21, MADEHURST WAY,
LITTLEHAMPTON,
WEST SUSSEX.
BN17 6HD.

ANNEXE FOR 16, MADEHURST WAY
LITTLEHAMPTON.

DRAWING	SCALE
PLANNING	1/100
DATE: OCTOBER 2017	
DRAWN: T. Murray	
DRAWING: 17/46/2	REVISION:

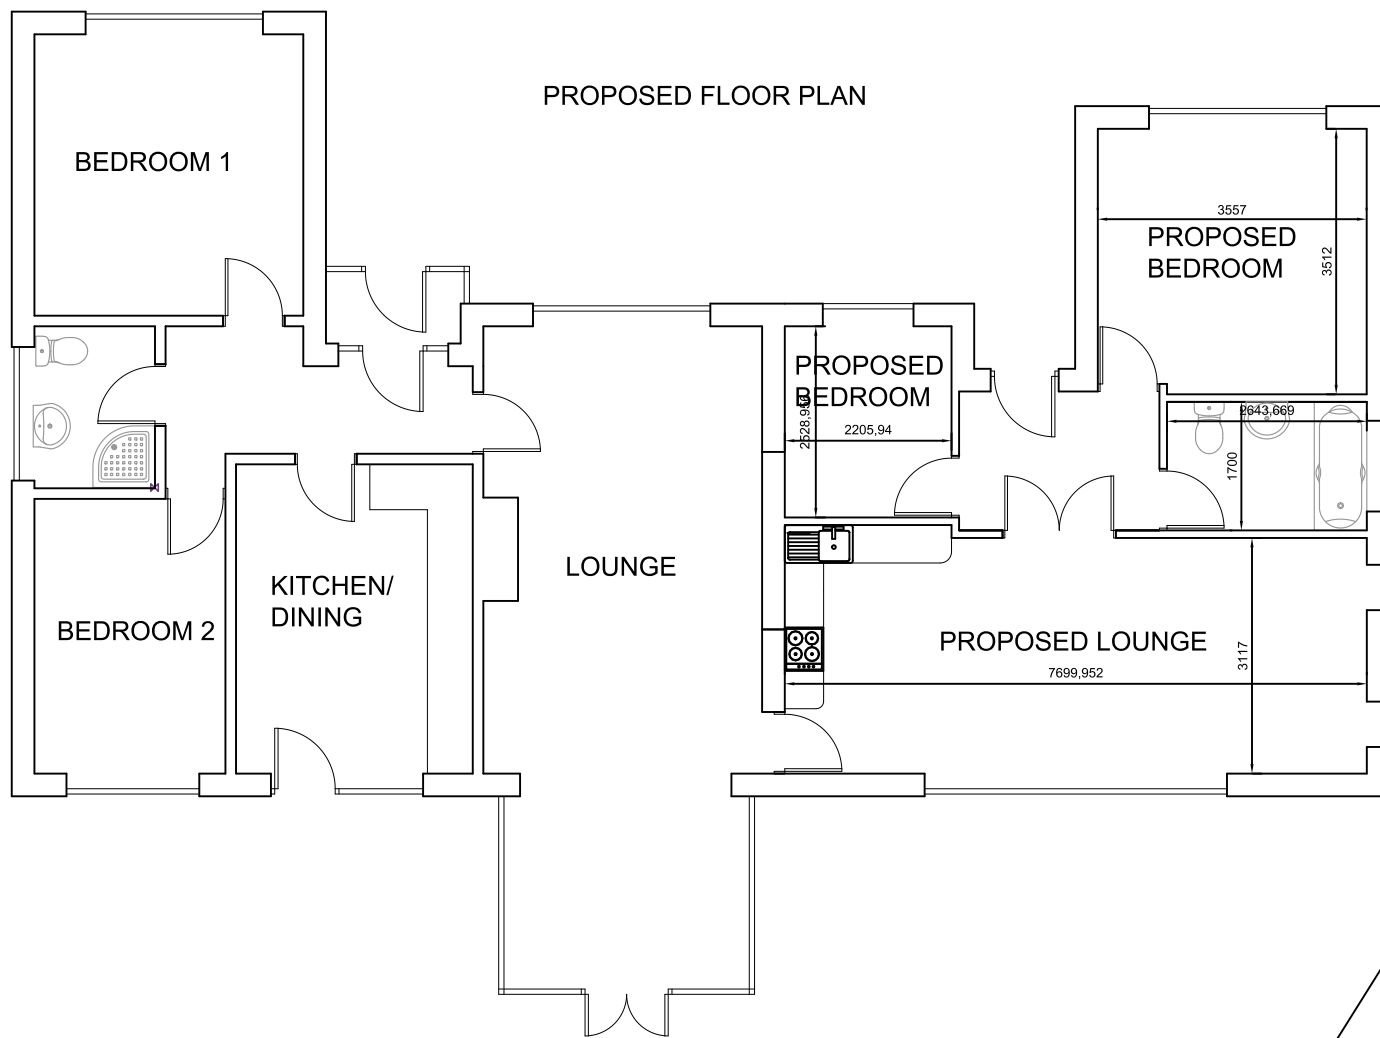
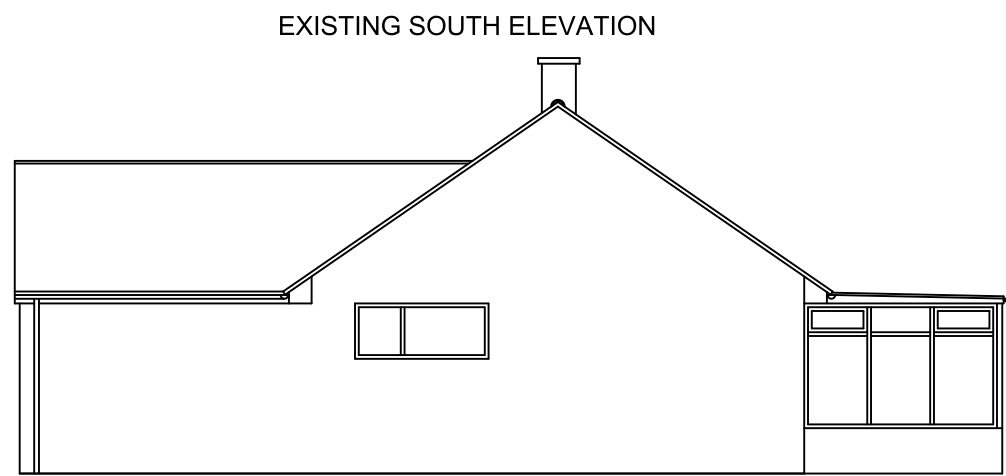
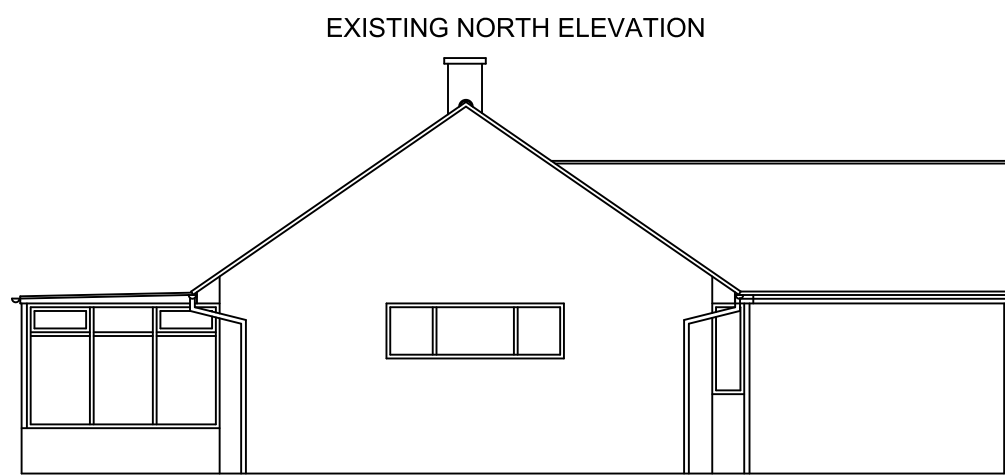
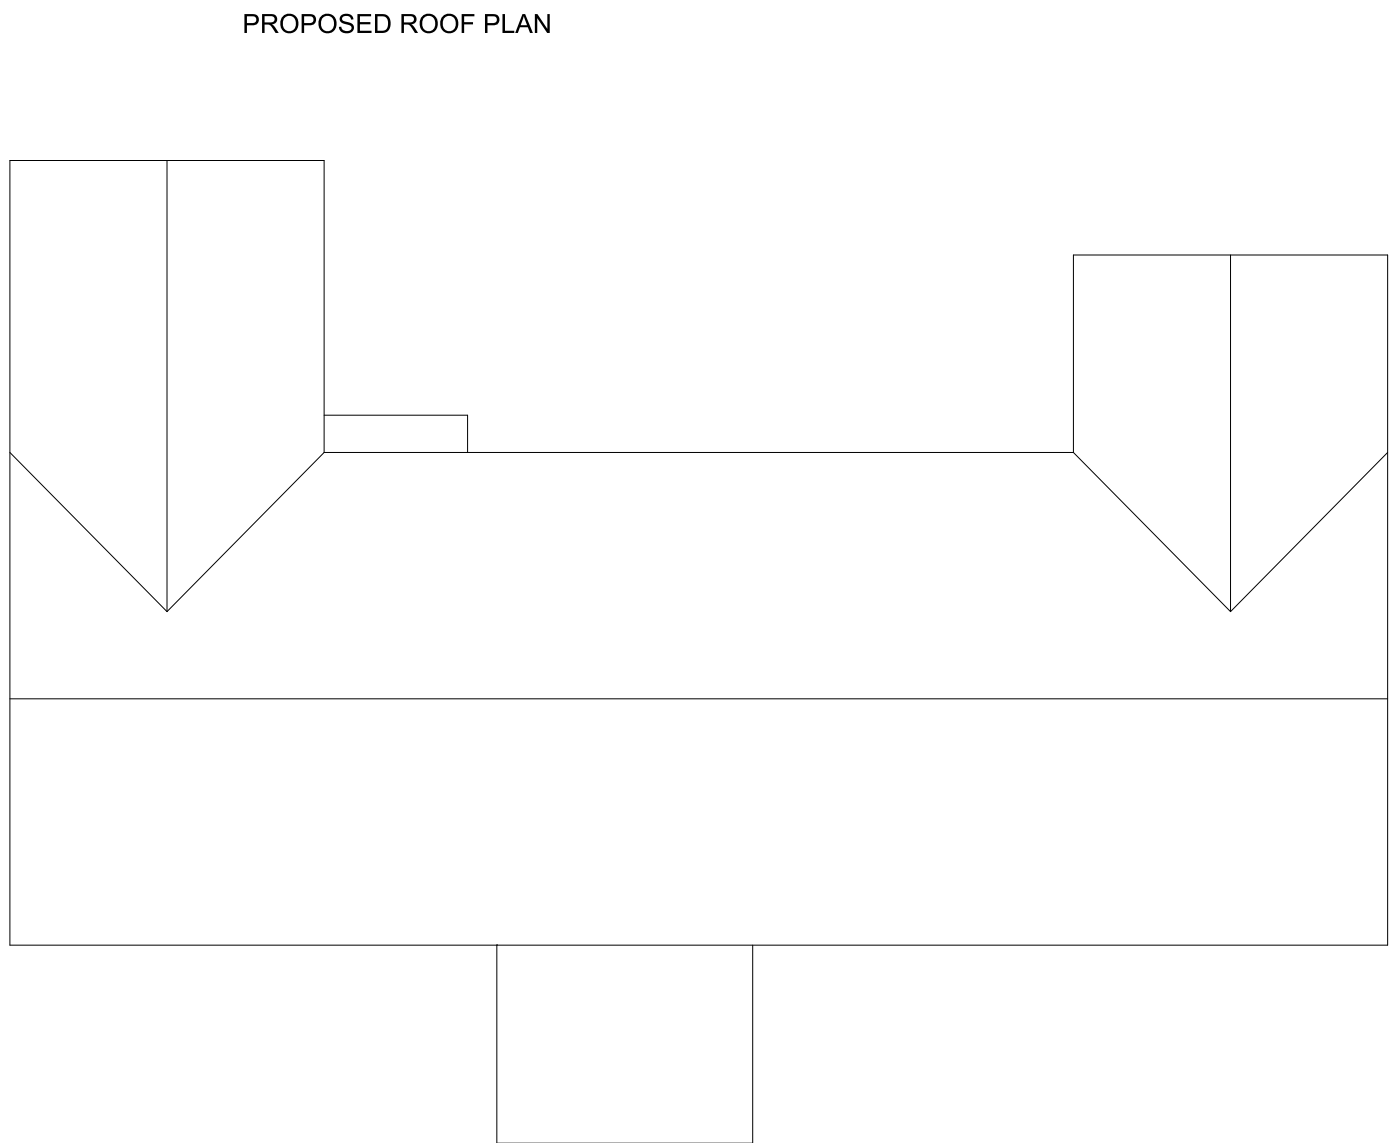
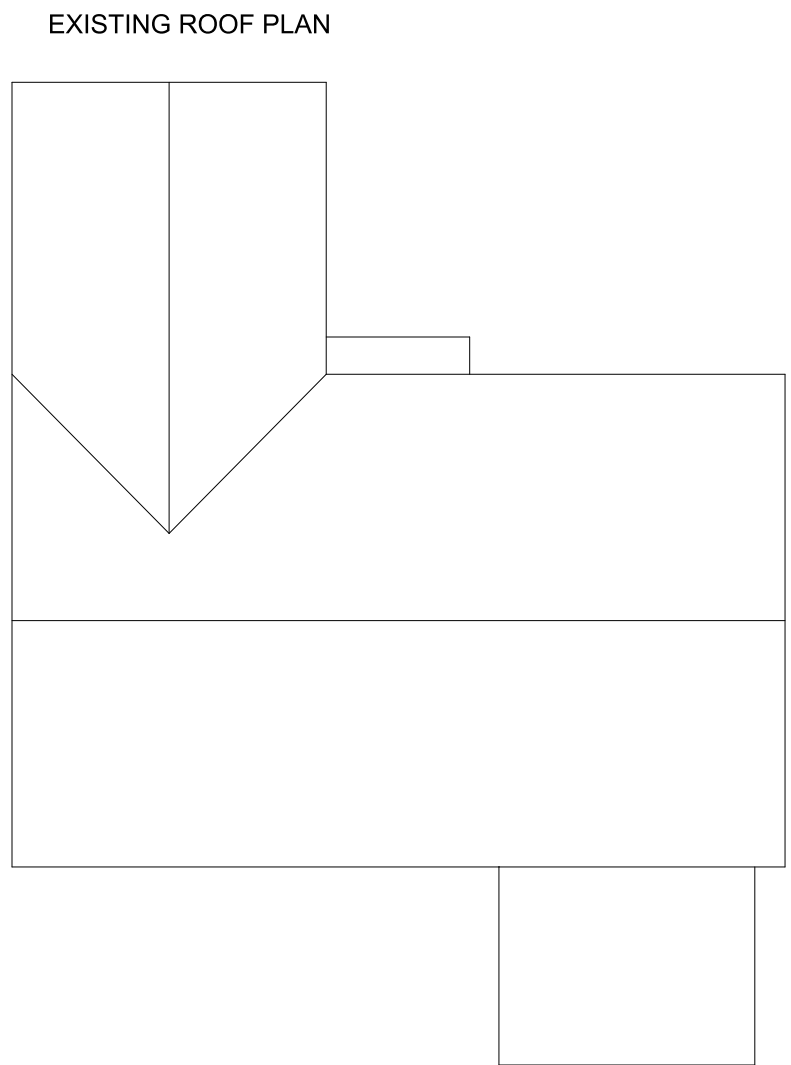
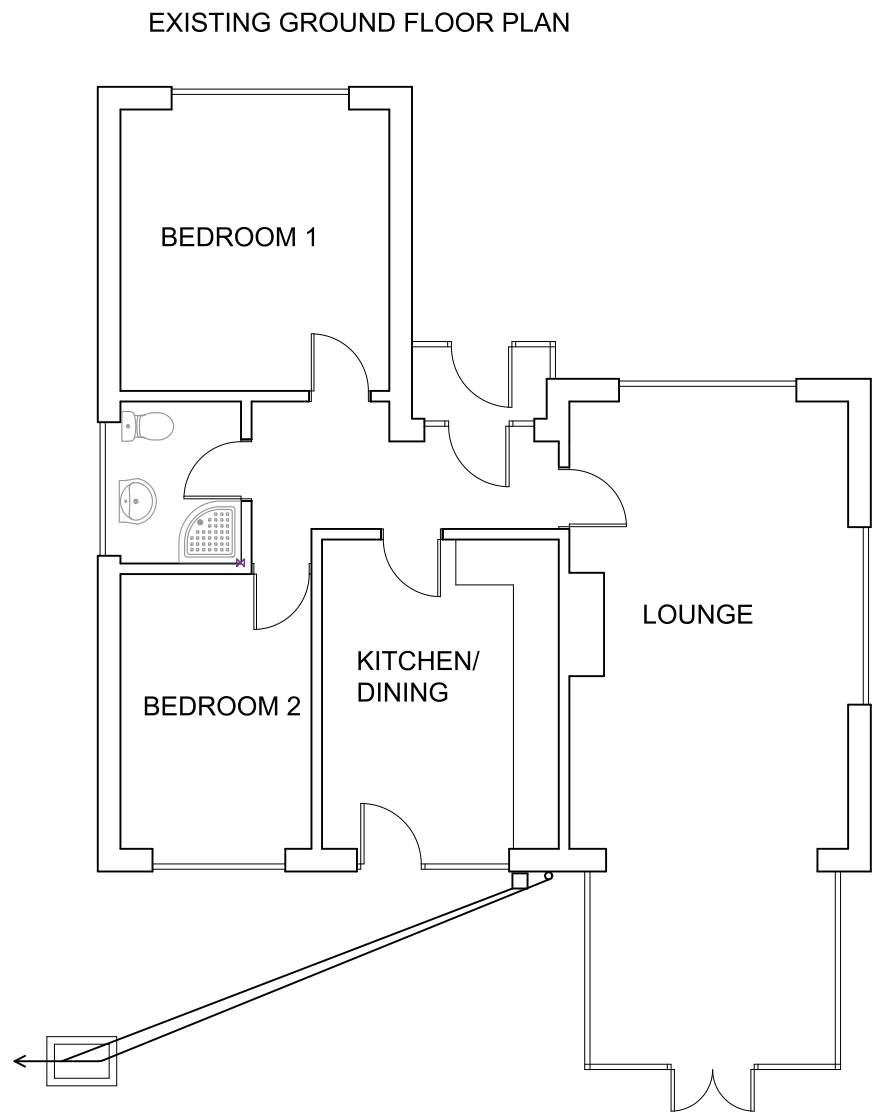
We feel this is not in keeping with the look of this estate, the annexe is too large for the plot. It looks like someone is trying to squeeze another bungalow on to the garden more or less the same size as the current one. It is far too big, & more or less meets the pavement on one corner destroying the park like green sward. Thereby encouraging others to do the same, ruining the whole ambience of the area. That is our objection.
